Department of Primary Industries

North Kellyville Public School (SSD 8344) Comment on the Environmental Impact Statement (EIS)

Alison Collaros
A/Director, Planning Policy & Assessment Advice
18 October 2017

Figure 1 Site and Catchment Map

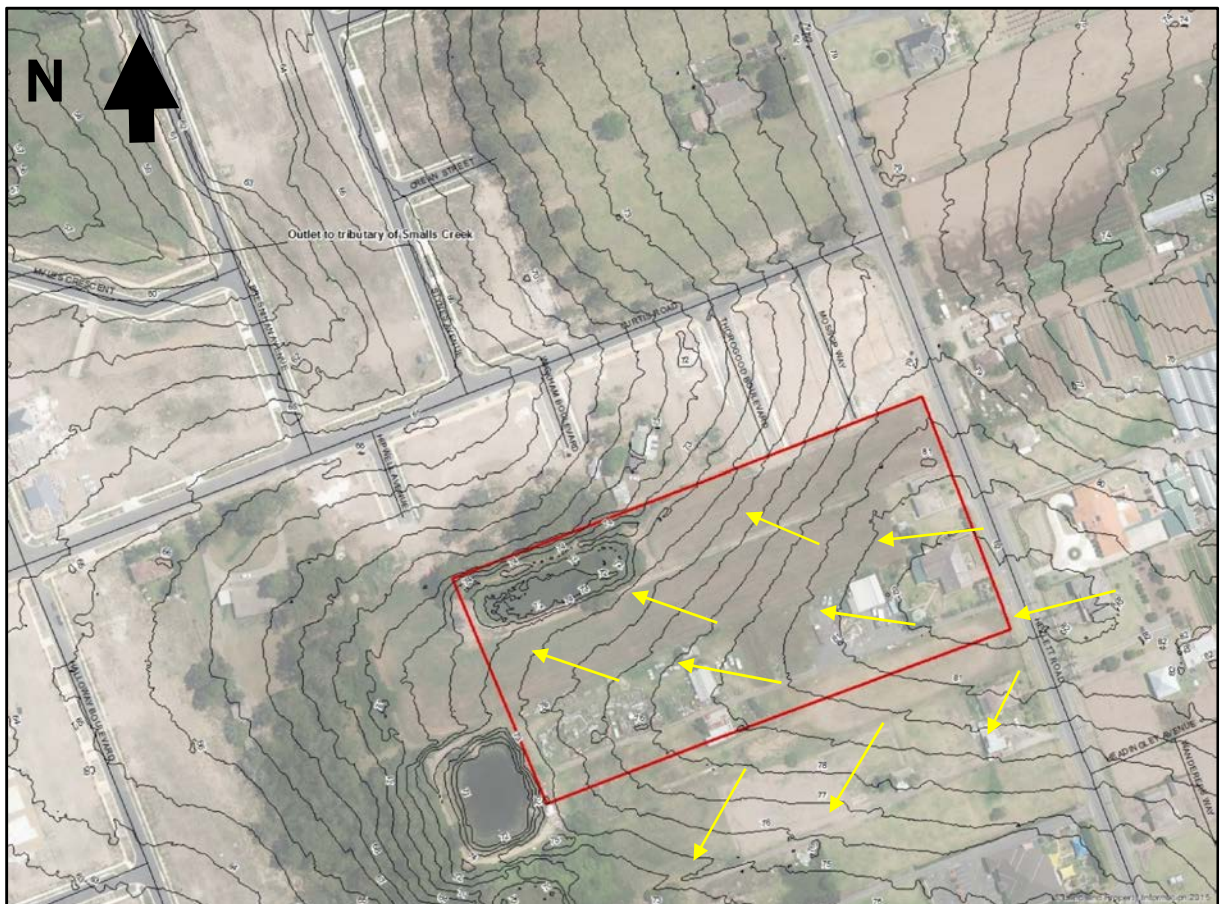
- The proponent should quantify the total volumes of water for the onsite dam, and for offsite dam 1.
- The following should be included as Conditions of Consent for any approval of the project:

- At completion of the decommissioning of the onsite dam and offsite dam 1, the proponent must report in writing to [Crown Lands and Water \(water.referrals@dpi.nsw.gov.au\)](#), that the decommissioning activity has been completed.
